CITY OF ALBUQUERQUE

Re: Plaza Cuauhtemoc Phase II, Traffic Circulation Layout
Engineer's Stamp dated 10-16-07 (M-09/D024)

**Re: Plaza Cuauhtemoc, Traffic Circulation Layout
Engineer's Stamp dated 4-01-05 (M9-D24)**

TRAFFIC CONTROL LAYOUT PLAN
PLAZA CUAUHEMOC

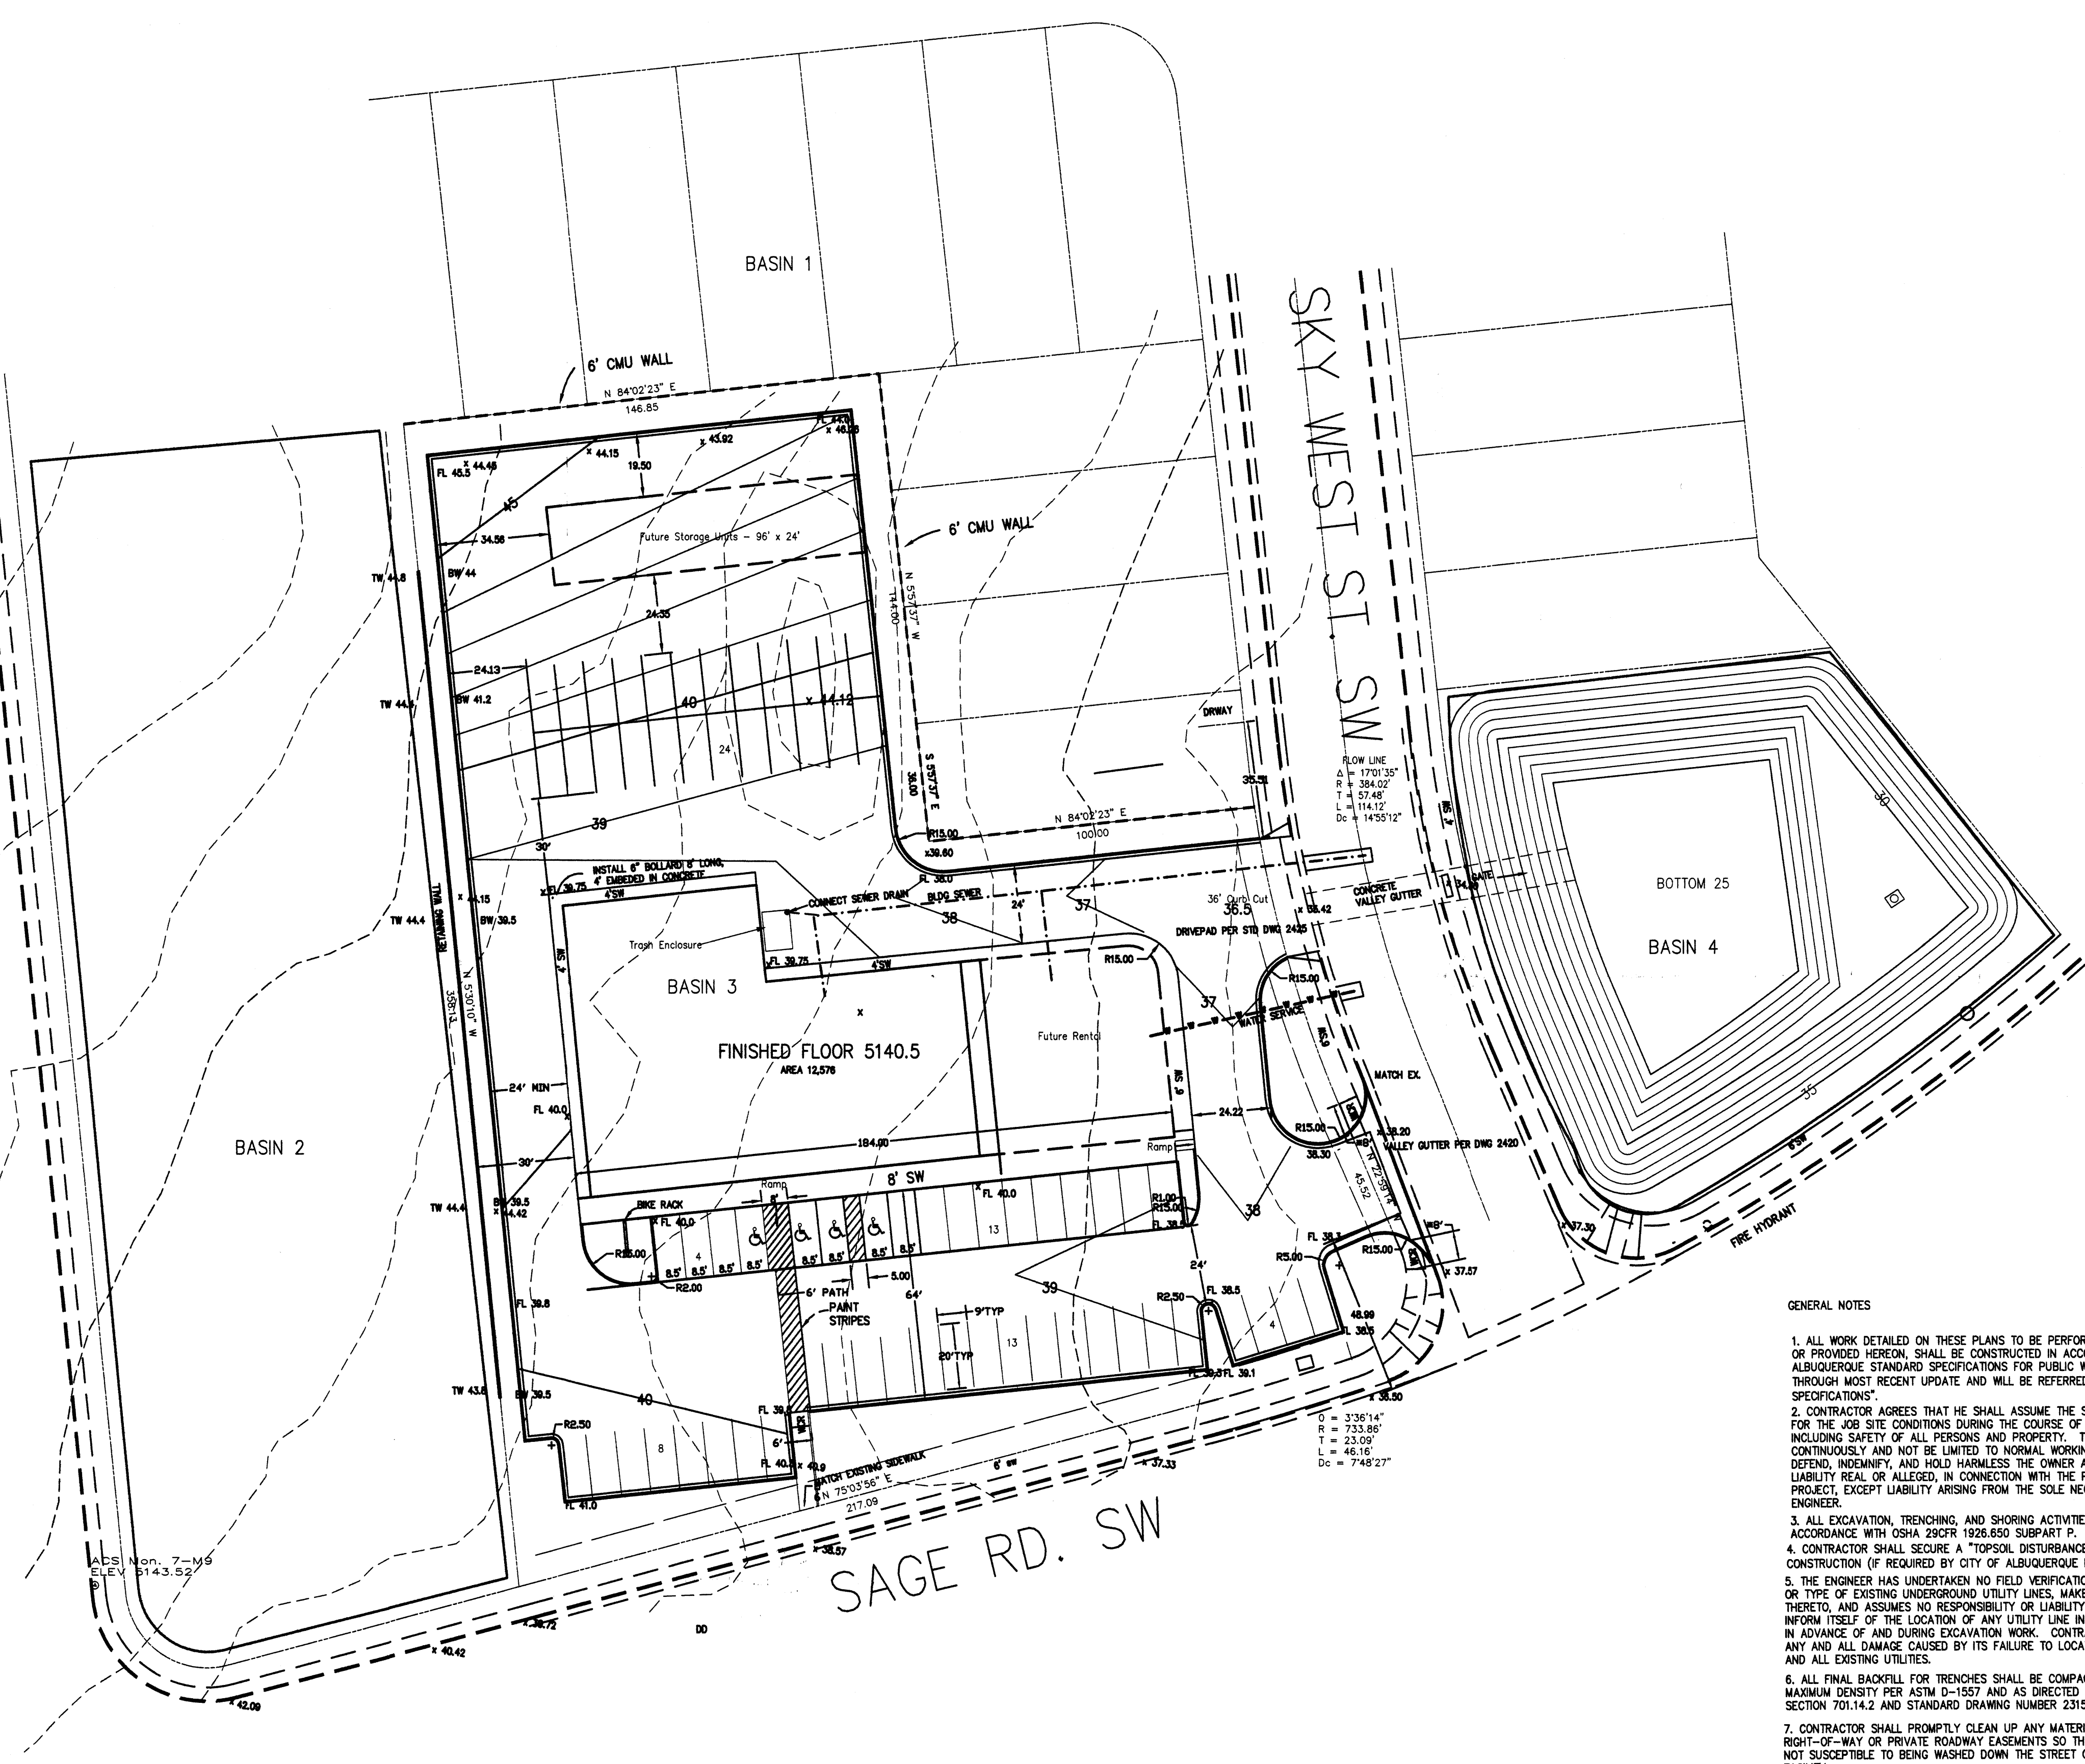
1. List radii for all curves shown. ✓
2. Please list the width and length for the wheelchair accessible parking spaces, as well as the access aisles. ✓
3. Label West Sky Street. ✓

4. Show the location of the nearest driveway on the adjacent lot. ✓
5. List the number of parking spaces required by the zoning code as well as the proposed number of parking spaces. ✓

6. Since Sage Road is a minor arterial, the drive must be at least 50 feet from the intersection. ✓
7. Is there an existing sidewalk on West Sky Street? Provide details. ✓

8. How is the northwest corner of the building protected from turning vehicles? *8" high 4' sidewalk*
9. Clarify existing versus proposed structures. ✓
10. Include two copies of the traffic circulation layout at the next submittal. *OK*

11. Please refer to all applicable city standards. ✓
12. Have you received Solid Waste approval? *YES, Dump pad on L.S. plan OK'd by S.W. man*
